**Attachment A – Detailed response to all submissions**

Green Square Integrated Facility and School – State Significant Development Application

DA-B69-XX-02

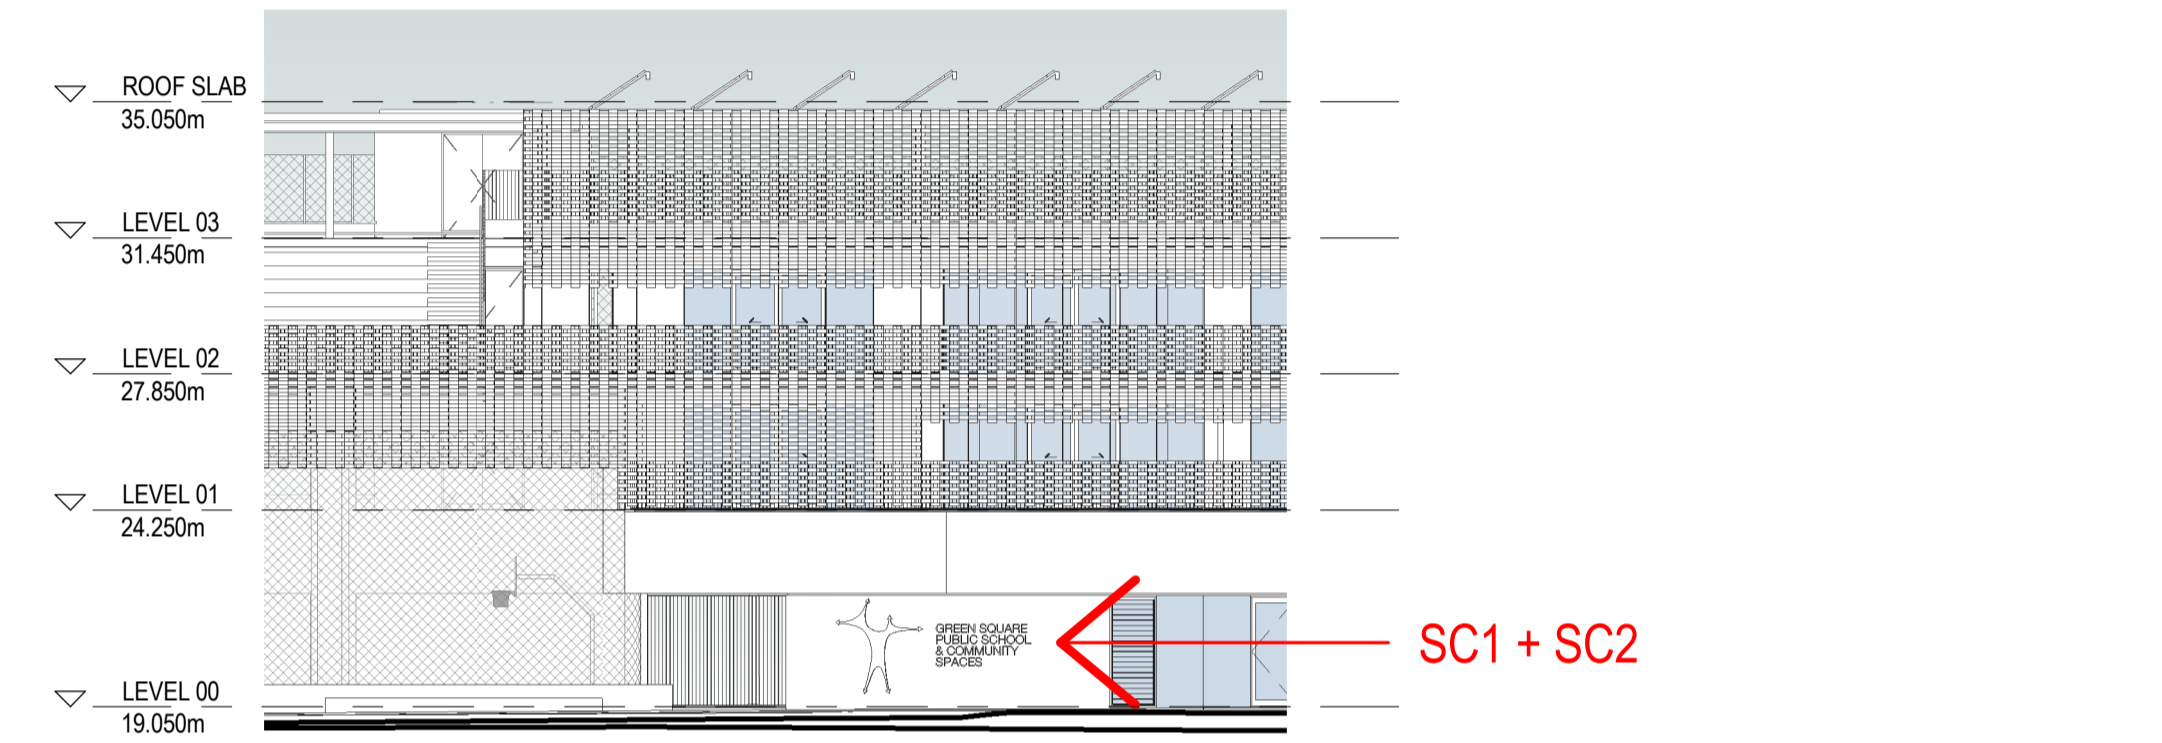
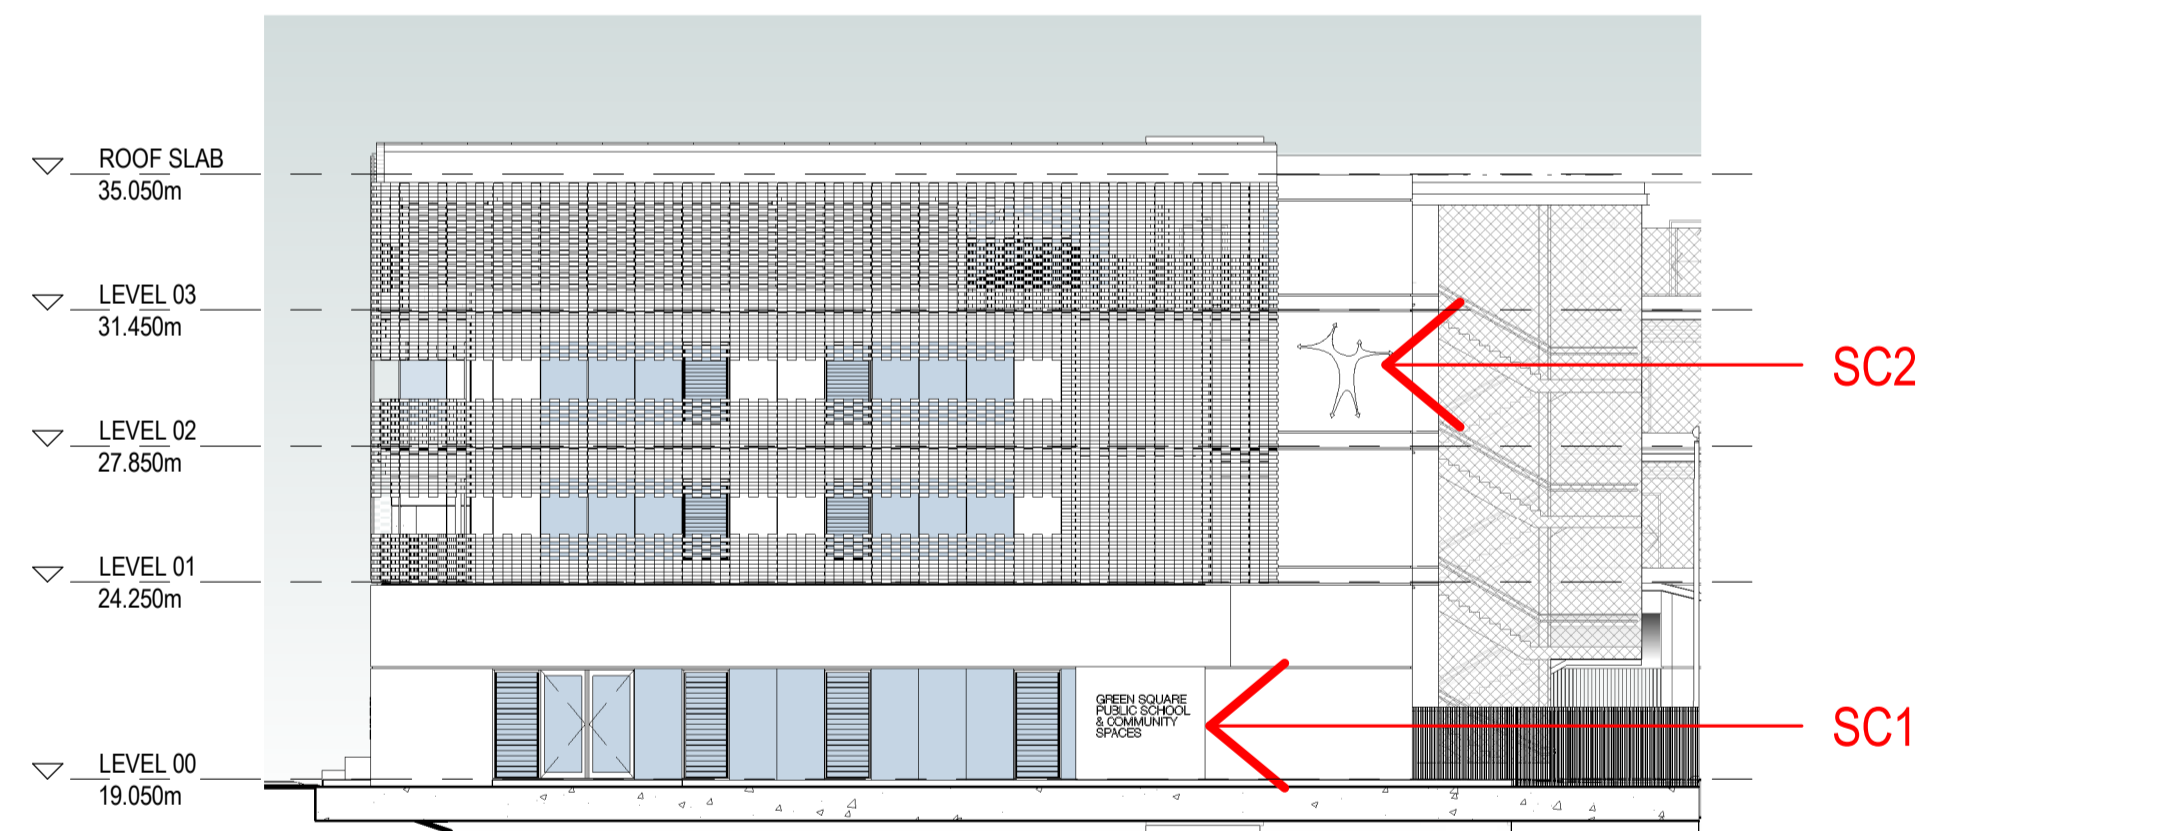
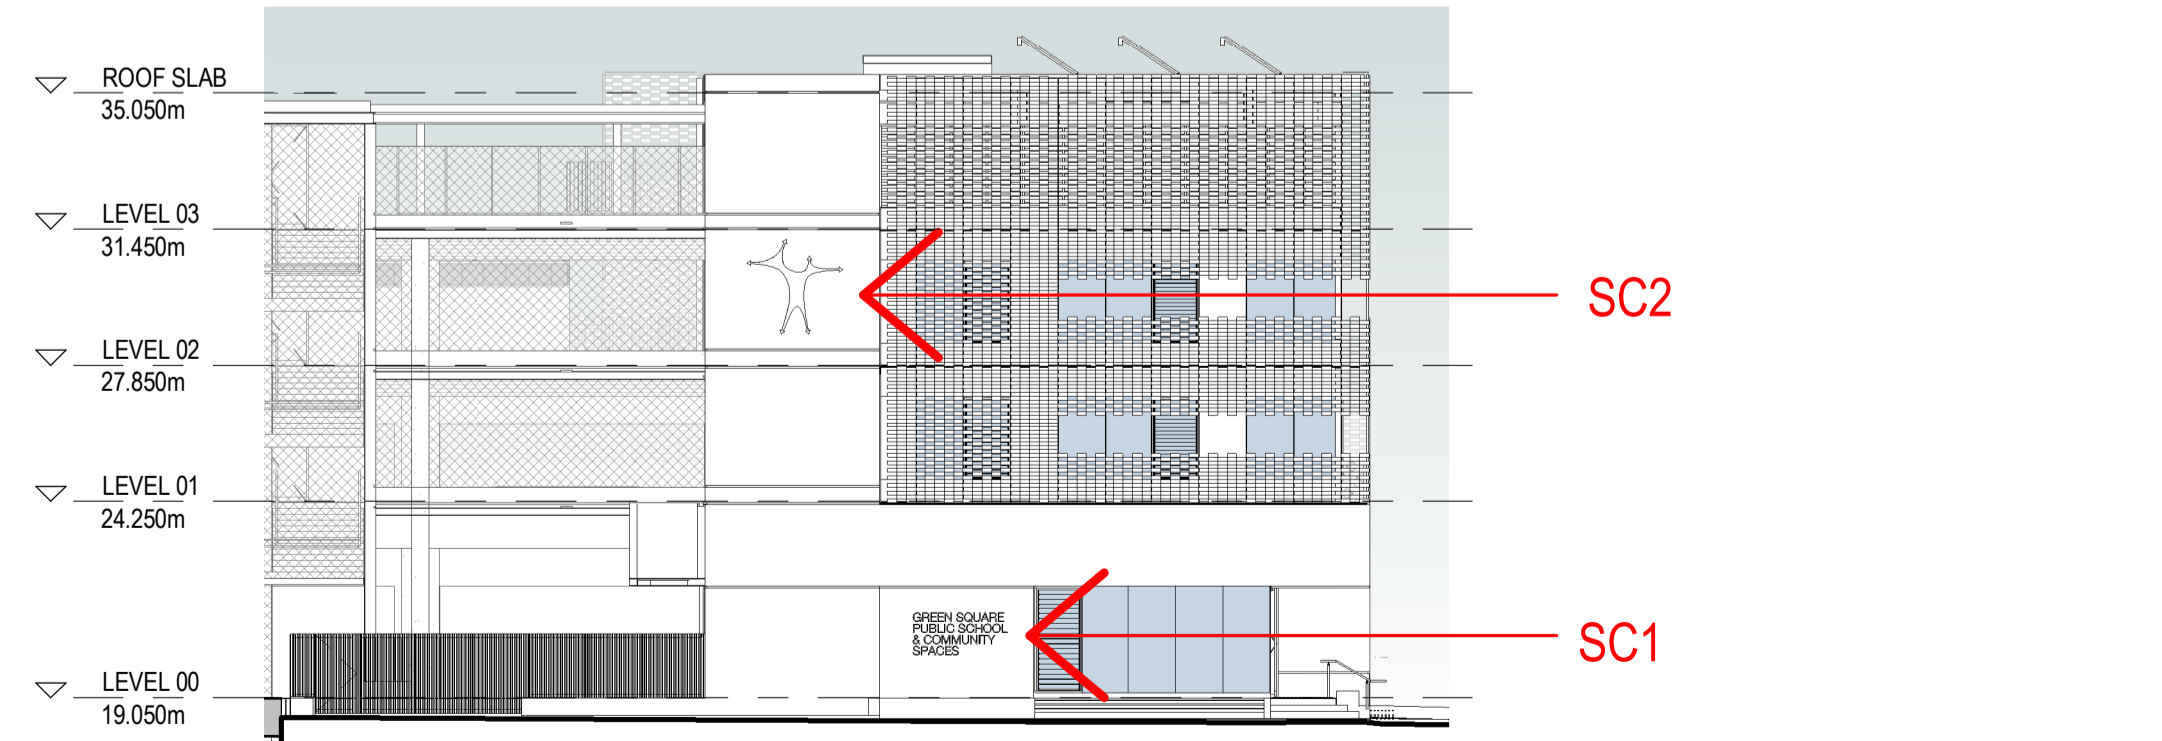
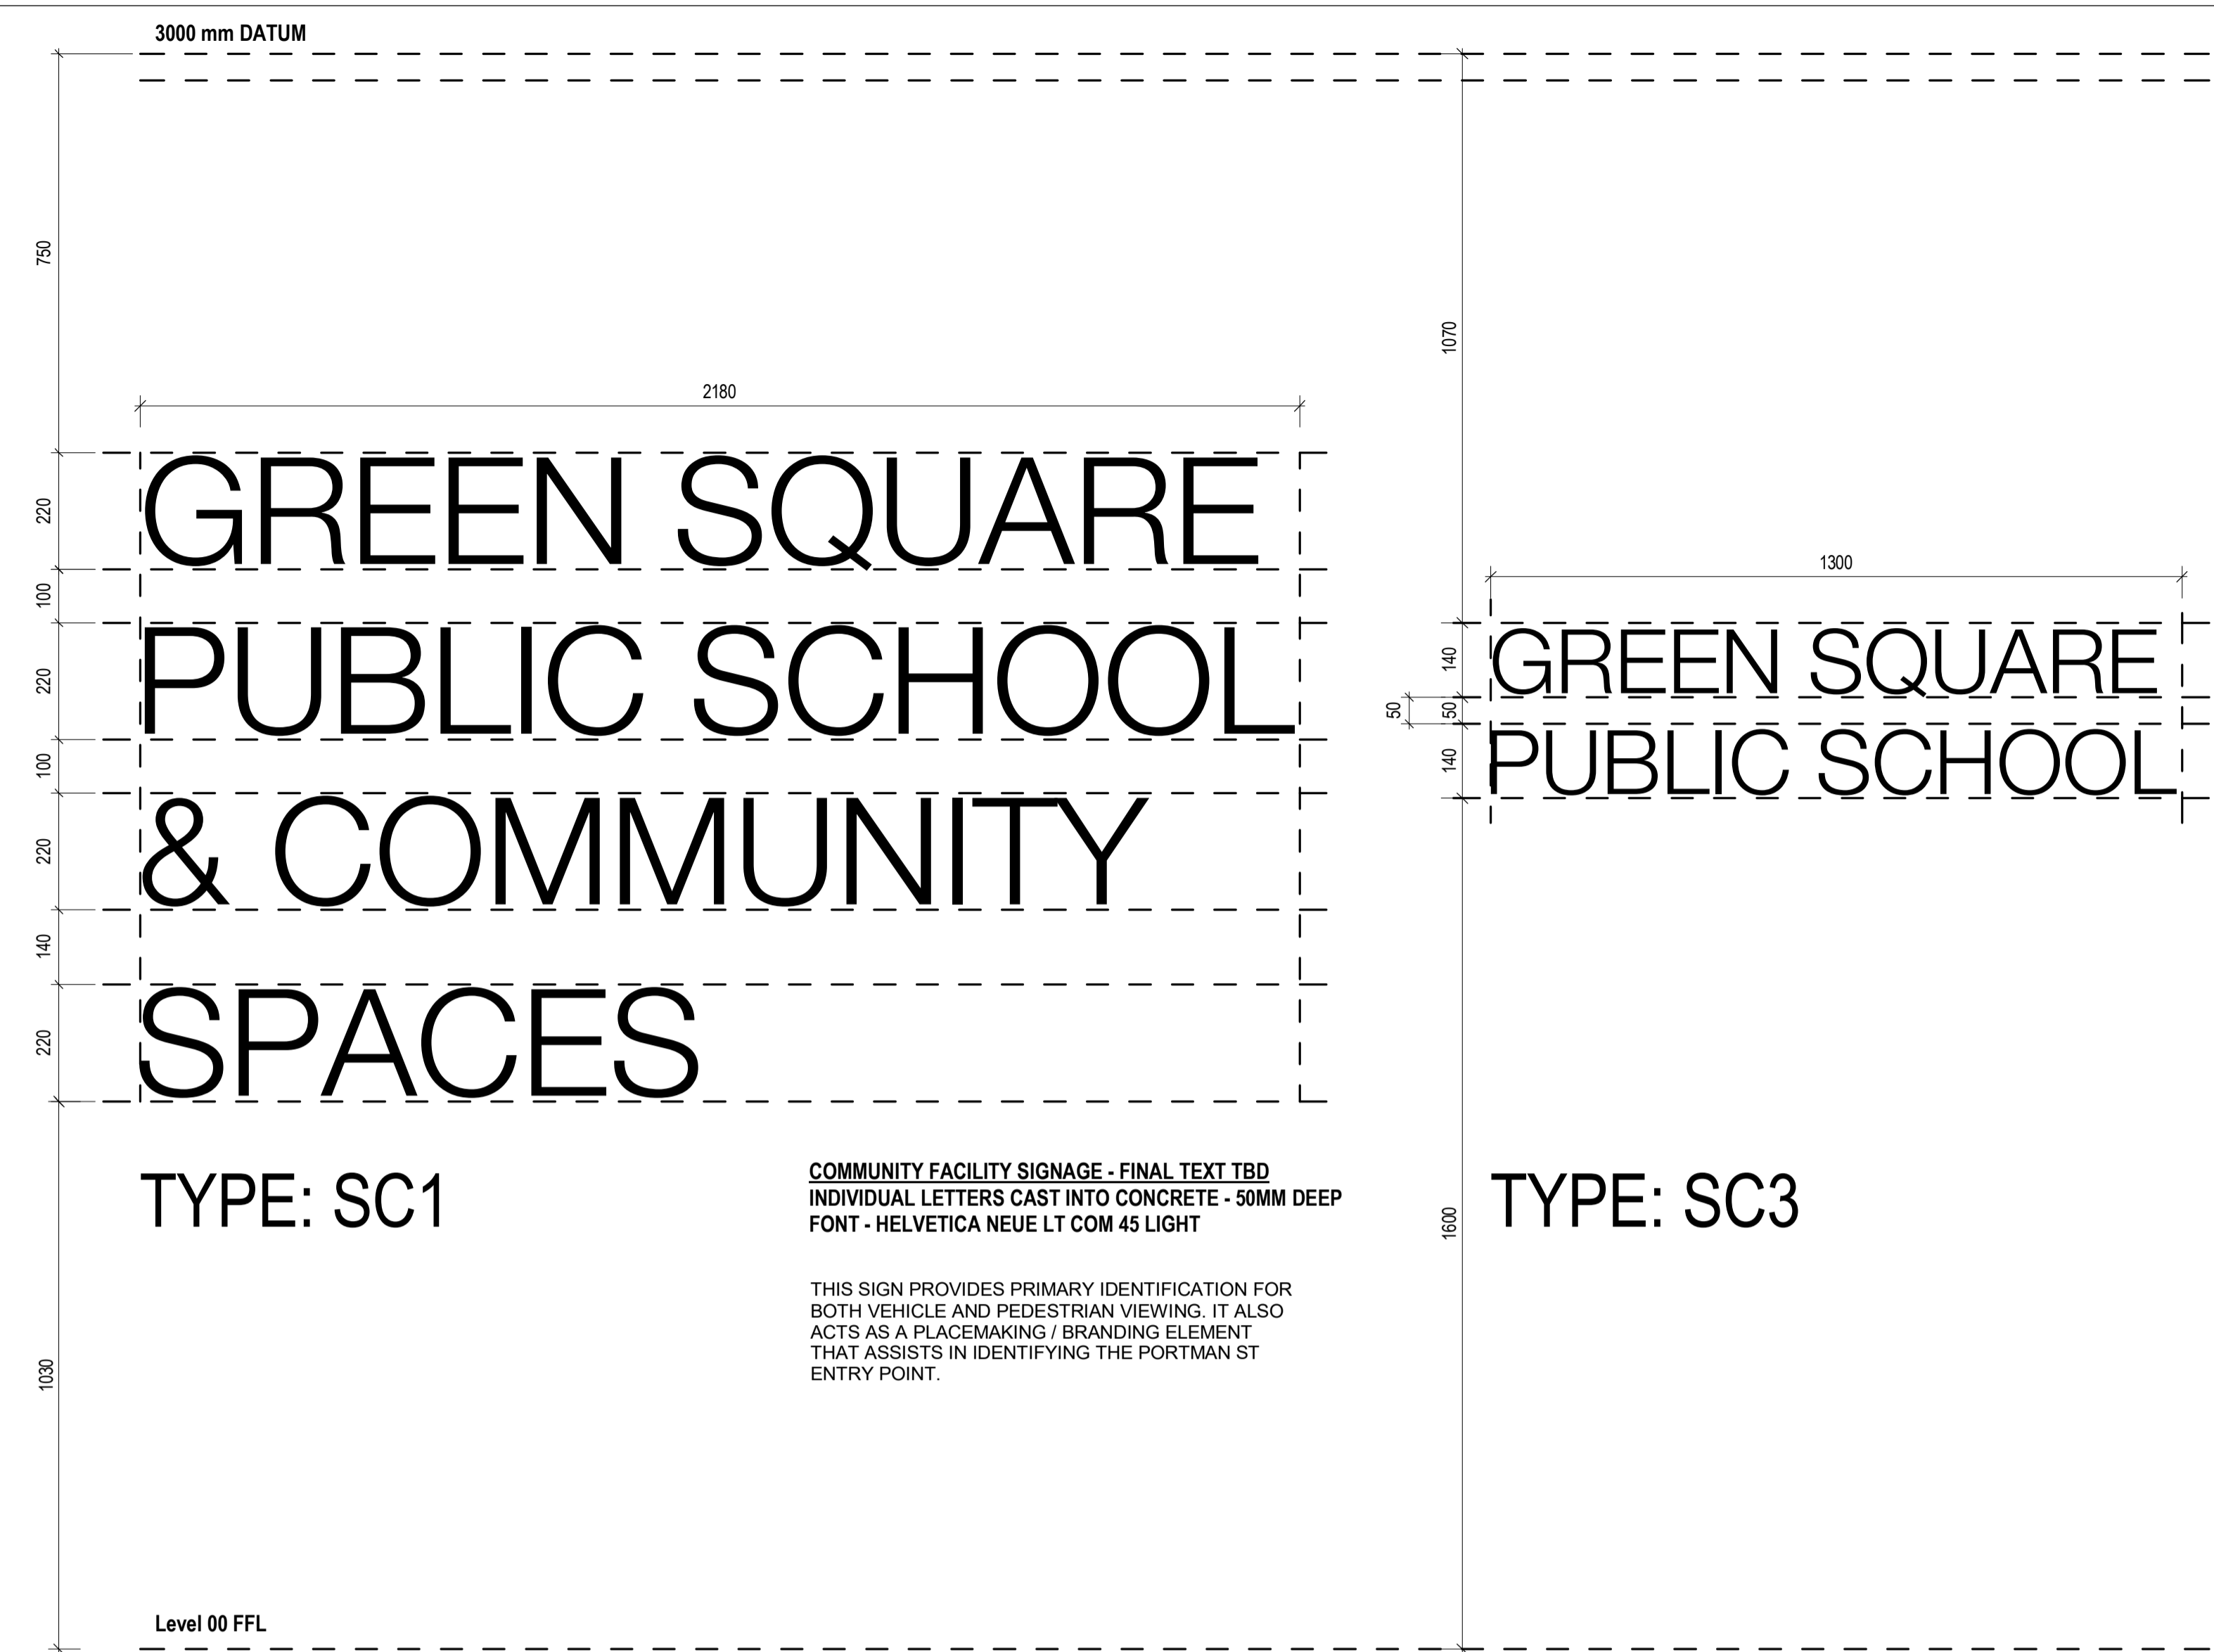
<p><u>Public Art</u></p> <p>13. <i>A Preliminary Public Art Plan is to be provided in accordance with the City of Sydney’s Guidelines for Public Art in Private Developments</i></p>	<p>13. A Preliminary Public Art Plan has been prepared by the Applicant (refer to <b>Attachment G</b>).</p>
<p><u>Signage</u></p> <p>14. <i>Signage details are to be included on the Architectural Plans including the floor plans and elevations and included in the visual amenity and view impact analysis.</i></p>	<p>14. Signage details have been updated on plans DA-B69-00-00, DA-B69-02-01, DA-B69-XX-01, DA-B69-XX-02 and DA-B69-XX-03 and included in the visual amenity and view impact analysis.</p>

Issue	Response
<p>15. <i>The proposed LED screen measuring 4000mm x 2000mm on the northern façade of the building is not supported in its current form given its size and associated visual impact. The sign should be amended to a smaller flush fitting, high quality material preferably non-LED editable sign appropriate to the proposal and its context.</i></p> <p><i>(Note: an amended assessment against SEPP 64 – Advertising and Signage is also required as it is considered that the assessment does not adequately assess the impact of the proposed sign)</i></p>	<p>15. The LED screen has been reduced in size by approximately 25%, from 2m x 4m to 1.5m x 3.5m (refer drawing DA-B69-XX-01). The operation of the LED screen will be limited from 6am to 10pm. This detail has been included in Section 14.3 of the updated Operational Plan at <b>Attachment E</b>.</p> <p>An amended assessment has been undertaken of the proposed signage against SEPP 64 (refer to <b>Attachment F</b>).</p>
